Project: AerCap House – MetroLink Submission

Subject: Review of MetroLink Rail Order

Prepared by: R.Osborne

Date: 20 March 2024

TUNNEL ALIGNMENT
SAINT STEPHEN'S GREEN – CHARLEMONT
RO APPLICATION VS DEEPER VERTICAL ALIGNMENT OPTION

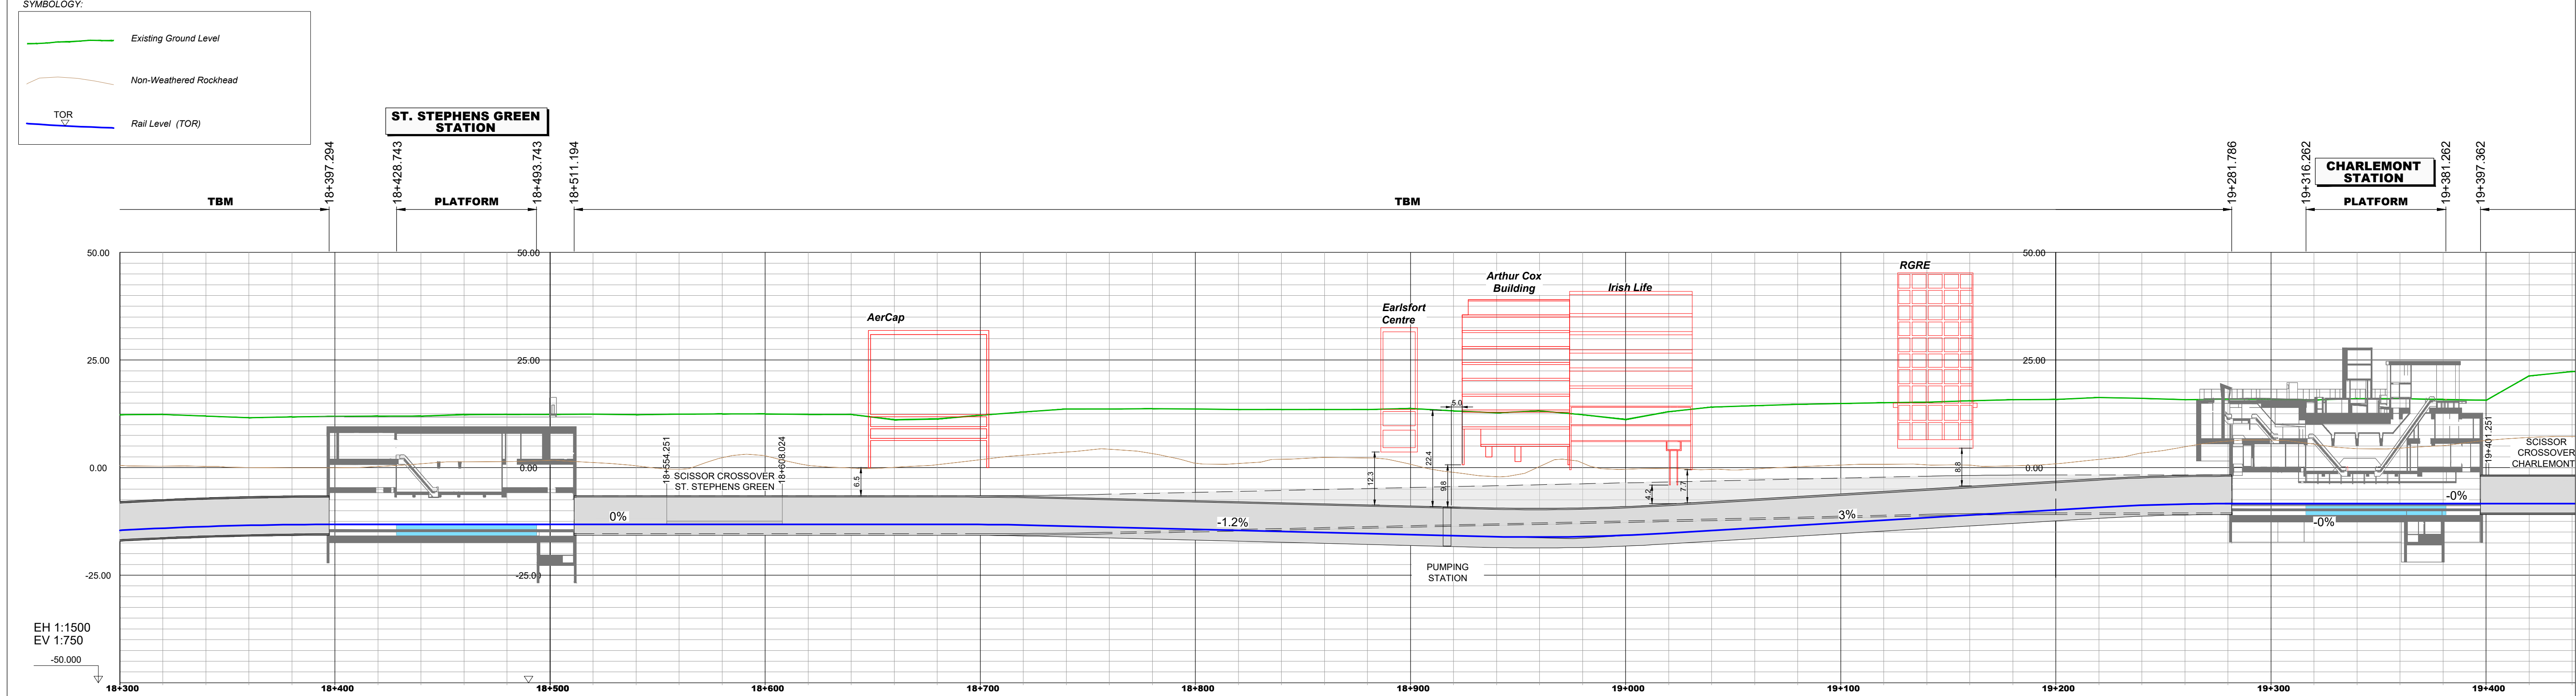
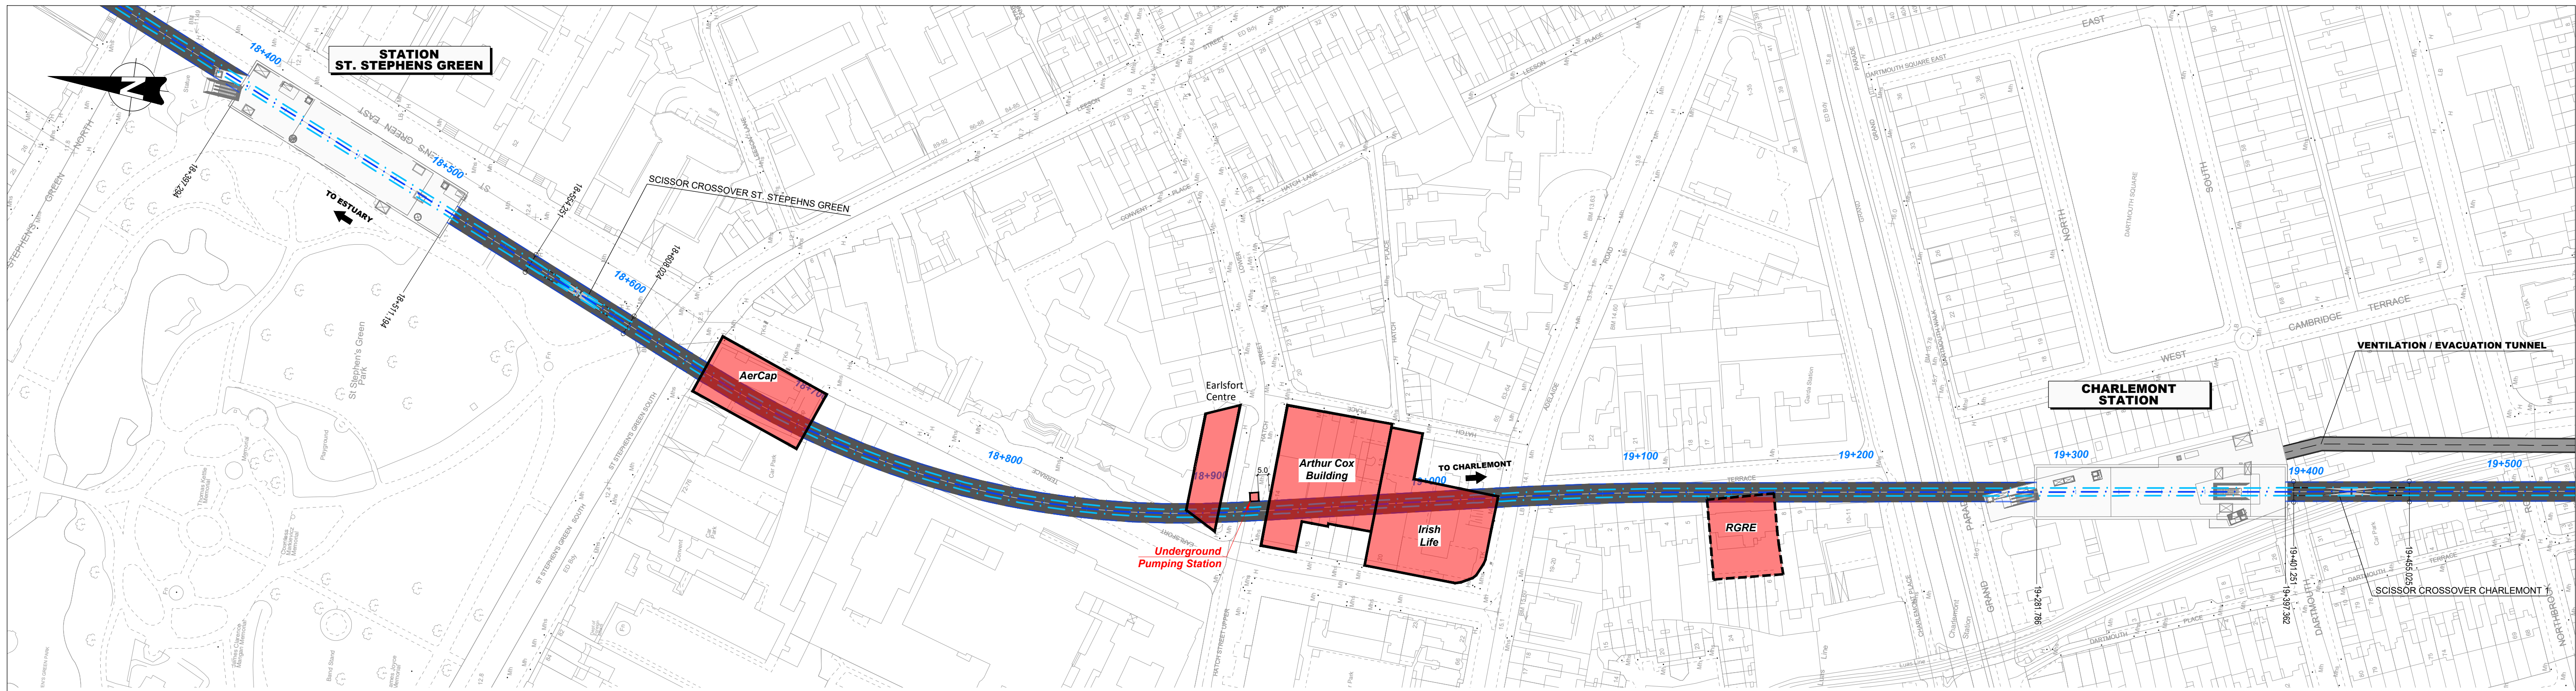
The expected settlement/subsidence has now further reduced to 22.14mm and has been categorised as Very Slight. We believe that this categorisation is incorrect.

As previously stated in our initial submission, the level of damage the AerCap Building could reasonably accommodate is less than 0.1mm. Even at this level, there are still concerns that the basement waterproofing system will be compromised and that remedial work will be required to be done to an occupied building.

If the Metrolink Tunnel is to pass under or close to AerCap House, we require a detailed Phase 3 assessment using the correct building geometry and structural form to be completed and independently verified, ensuring the maximum damage caused to AerCap House is limited to 0.1mm cracking. We still believe the proposed tunnel elevation may be lowered further, possibly more than the current LOD downwards would allow.
